Subject: app3/2012/1085 Kirkmoor Road, Clitheroe

I would raise no objection to the proposal on highway grounds but would request that the following condition be attached to any permission that may be granted.

Proposed Site Plan scale 1:100

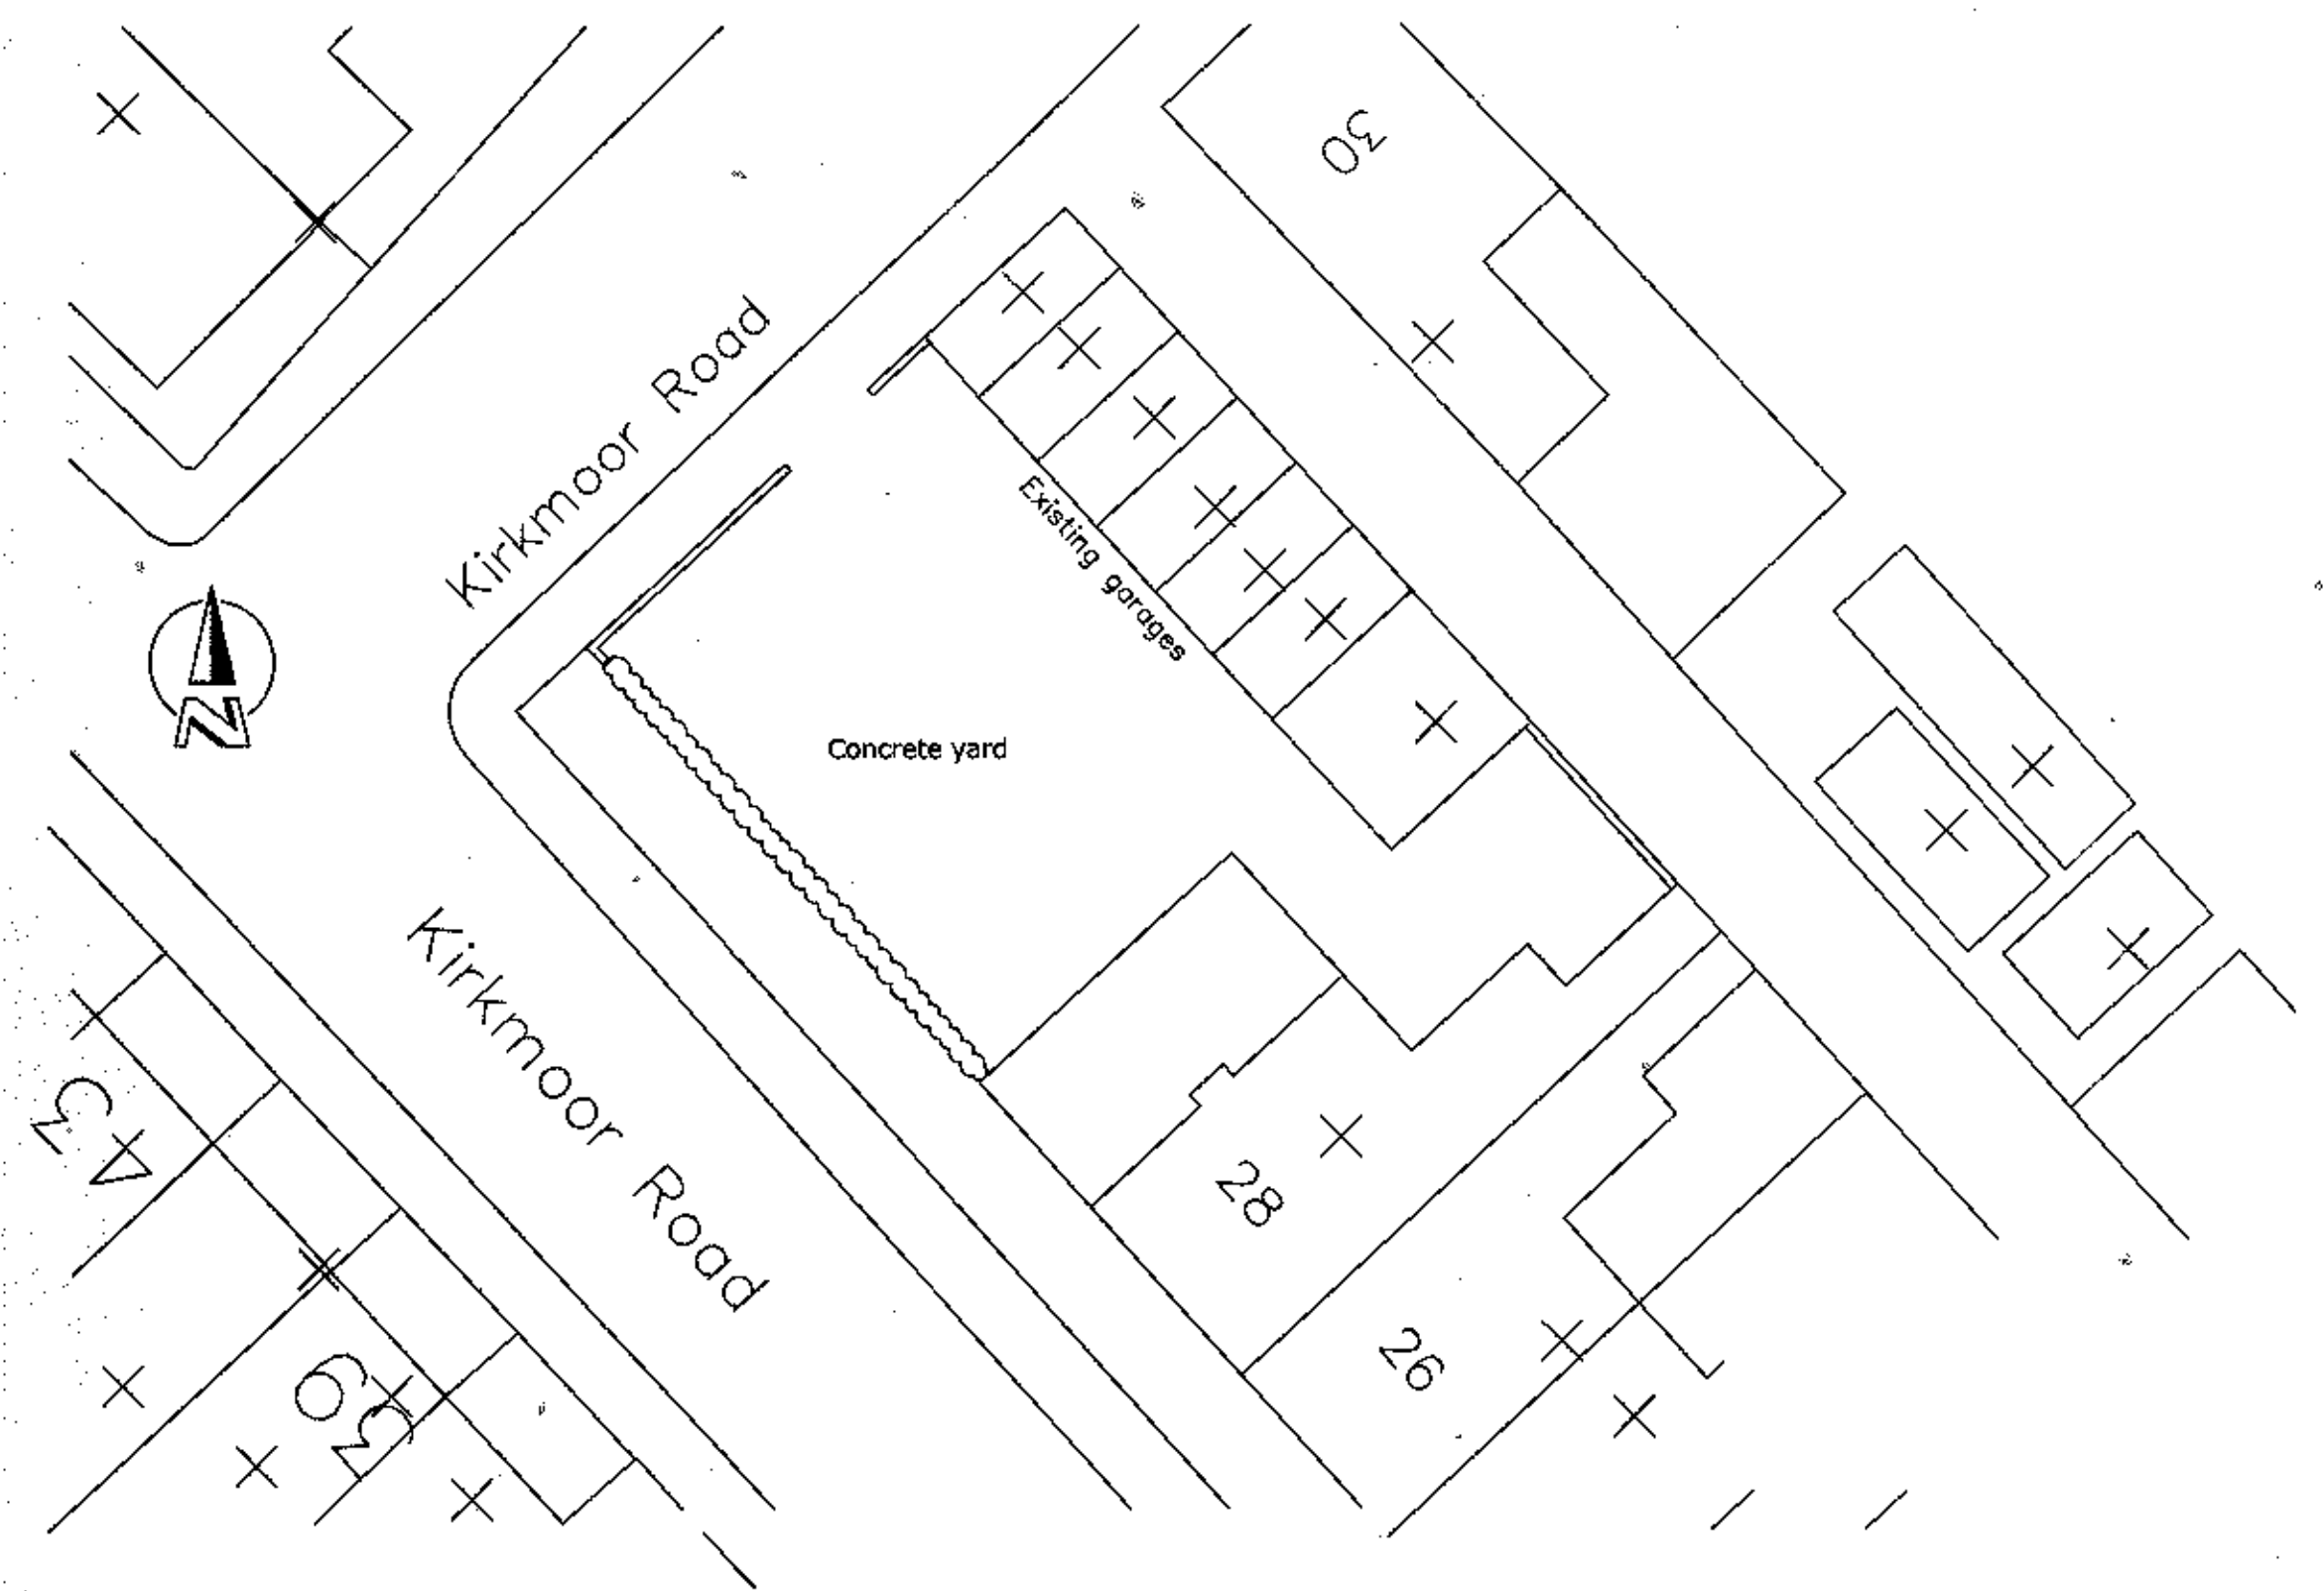
1 The proposed boundary wall fronting Kirkmoor Road shall be constructed and maintained at a height not exceeding 1.05 metres. Reason to maintain sight lines at the Kirkmoor Road/Kirkmoor Road Junction.

2 The vehicular access to the parking area to the side of 28 Kirkmoor Road shall be properly constructed to provide a vehicular access adjacent to No.28. Currently the footway construction is incomplete. Reason to maintain the proper construction of the footway.

The provision of the access and reconstruction of the footway as referred to in condition 2 above will require the provision of new drop kerbs and alterations to the footway. The construction and maintenance of these items must be completed in accordance with a scheme to be agreed by the Local Planning Authority in conjunction with the Highway Authority.
